Name: Kesti Suggs
Address: 14445 Holmes Road

Markup Summary

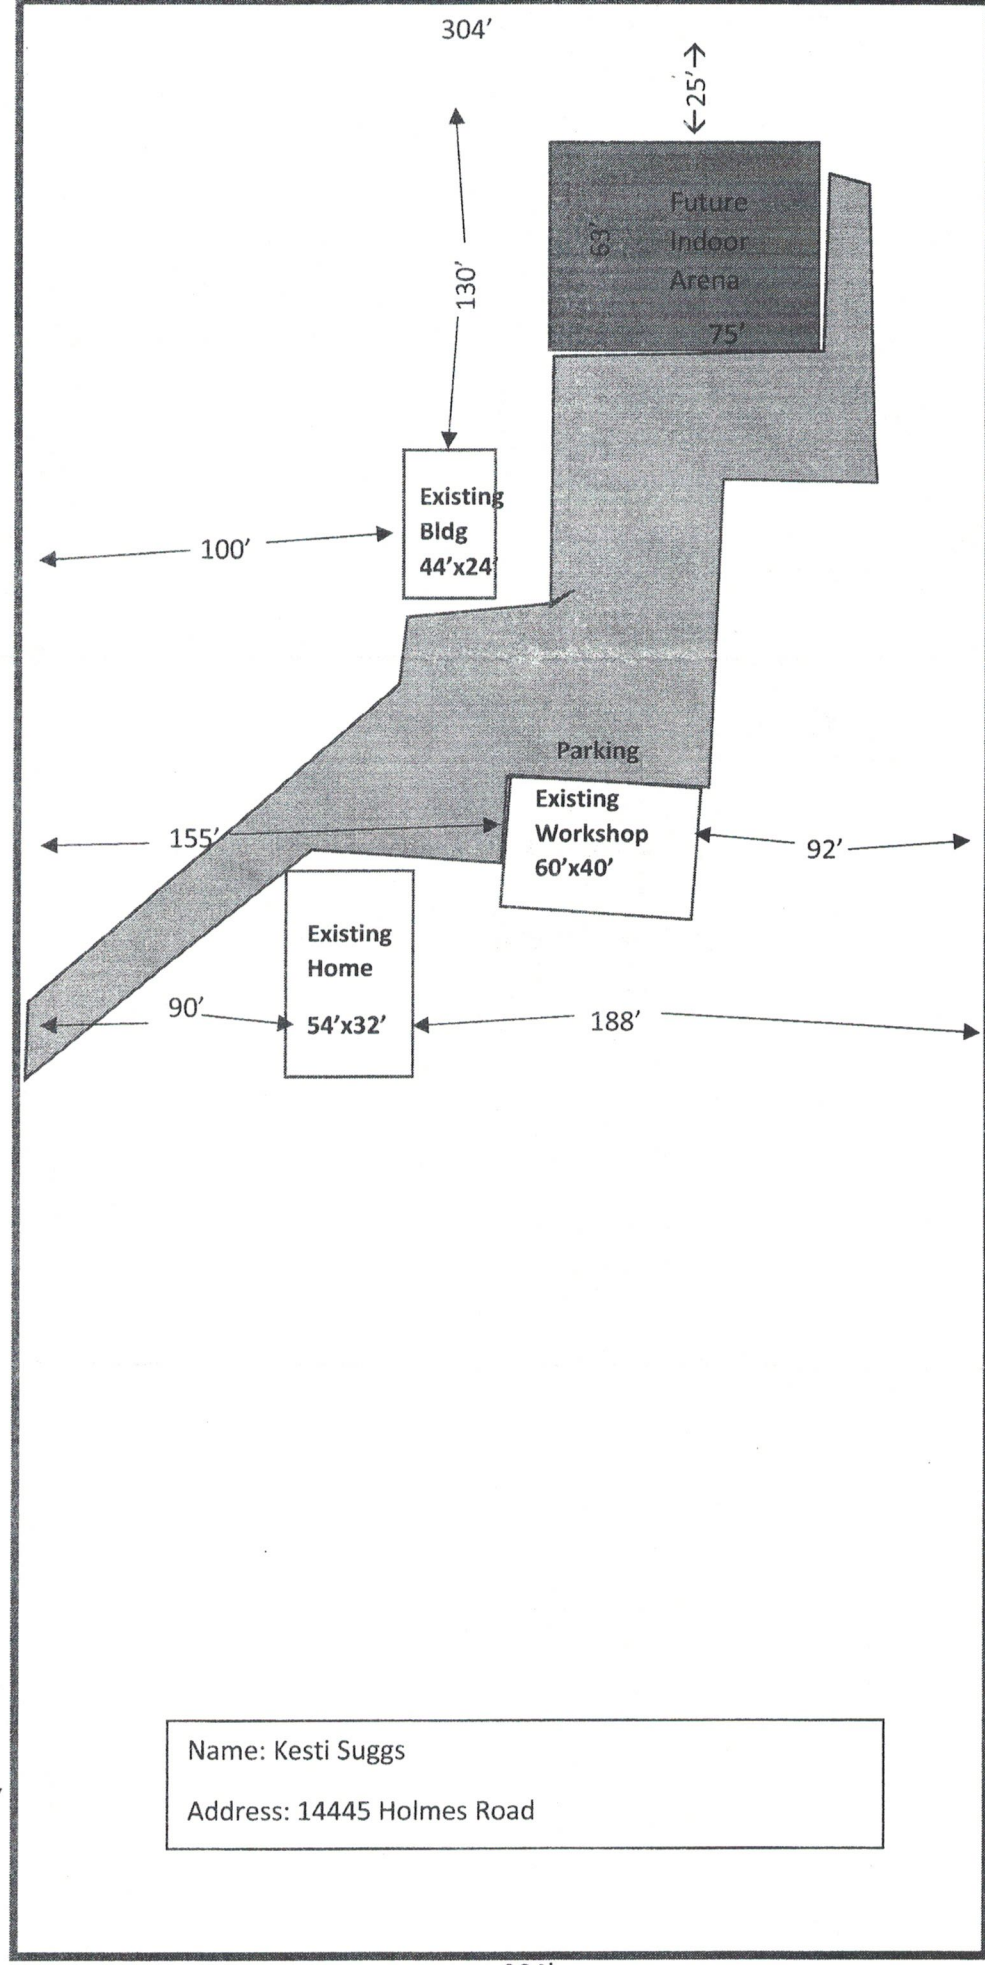
Move these down do eliminate confusion with the future indoor arena setback looking larger but being smaller.

Show Dumpster
